From: Boryn, Agnes <agnes.boryn@westyorkshire.police.uk>
Sent: 13 January 2026 11:02
To: Victor Grayson; DC Admin
Subject: DOCO comments for application 2025/93449 at land east of Abbey Road North, Shepley, Huddersfield, HD8 8FG

Re: 2025/93449- Discharge of details reserved by conditions 27 (crime prevention), 29 (boundary treatments), 30 (external lighting) and 31 (landscaping) of previous permission 2024/90991 for variation of conditions 2 (plans) and 28 (materials) of previous permission 2020/93358 for erection of 52 dwellings

Drawing No: 8834-BOW-A0-ZZ-DR-A-1050

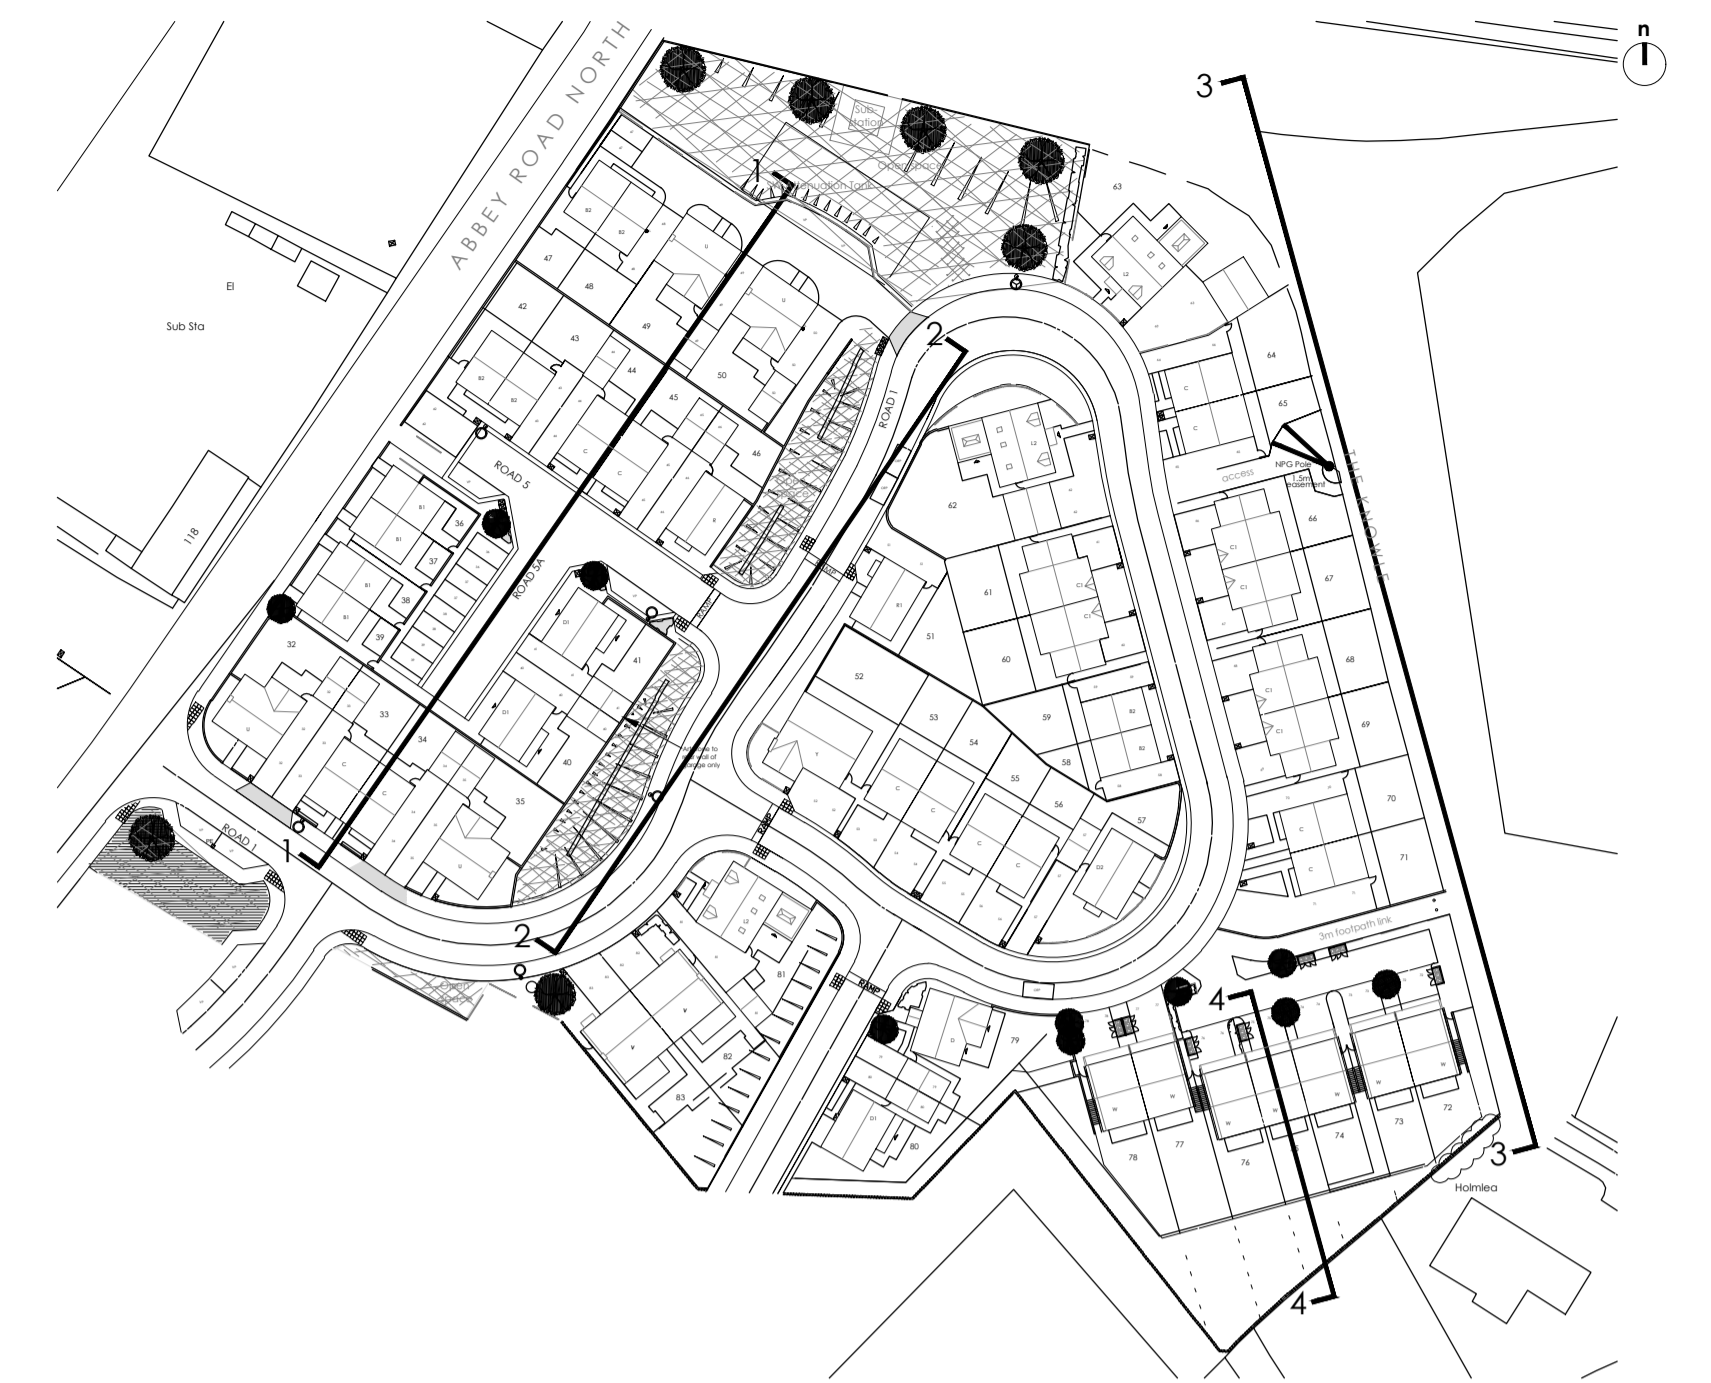
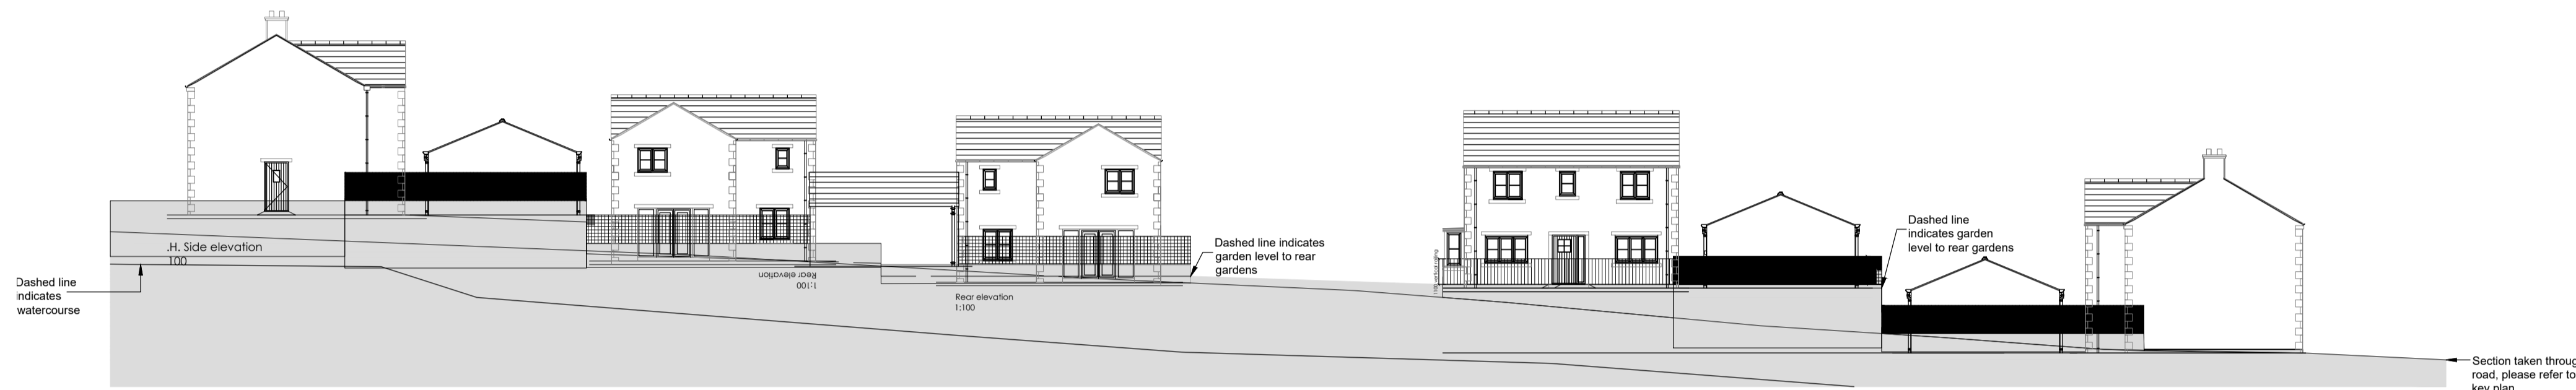
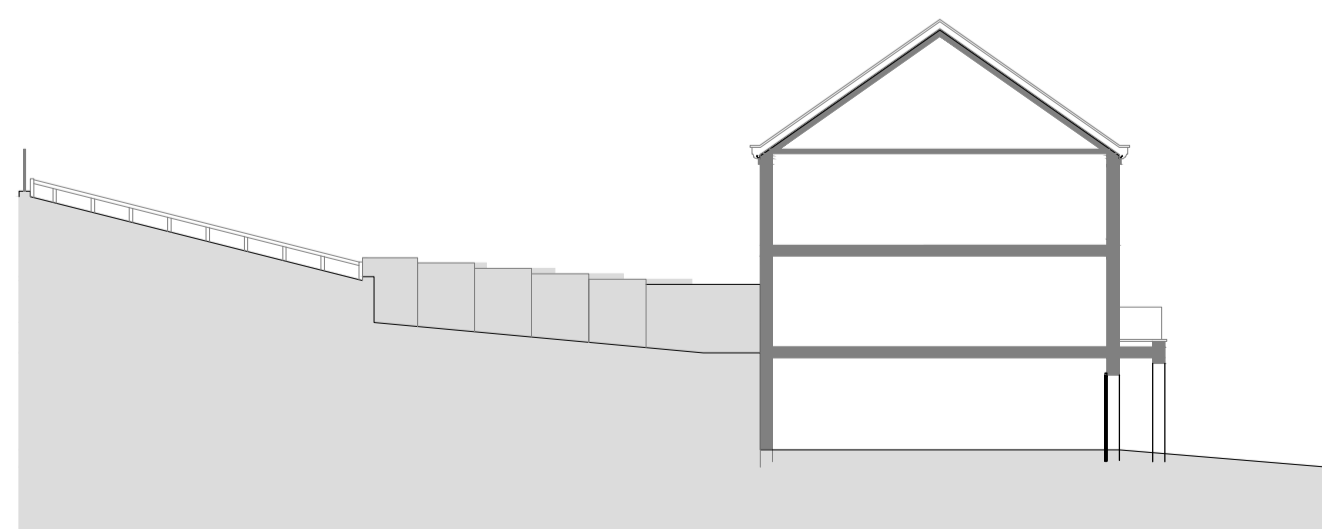
With regard to boundary treatments consisting of walls topped with trellis fencing- all trellis panels on the external face should be located flush to the edge of the wall to deter climbing and its use as informal seating.

Plot 32- street-facing side of rear garden appears to be enclosed only with a 0.9m dry stone wall; this is insufficient in terms of security. The boundary should be raised to at least 1.8m along the lines marked in pink below:

Plot 35's rear garden also has a weak point in its boundary for the same reason (marked in pink below)-this requires raising to 1.8m:

Plots 72 & 83- side/ rear boundaries abutting private gardens (marked in pink below) appear to feature a 1.1m post and wire fence only- this is insufficient security wise and should feature wall/ fencing to the height of at least 1.8m:

Where railing adjoins boundaries to private rear gardens, it should be vertical rather than horizontal so it does not become a climbing aid and assist unauthorised access. This is the case for plots 57, 62, 63 and 64.
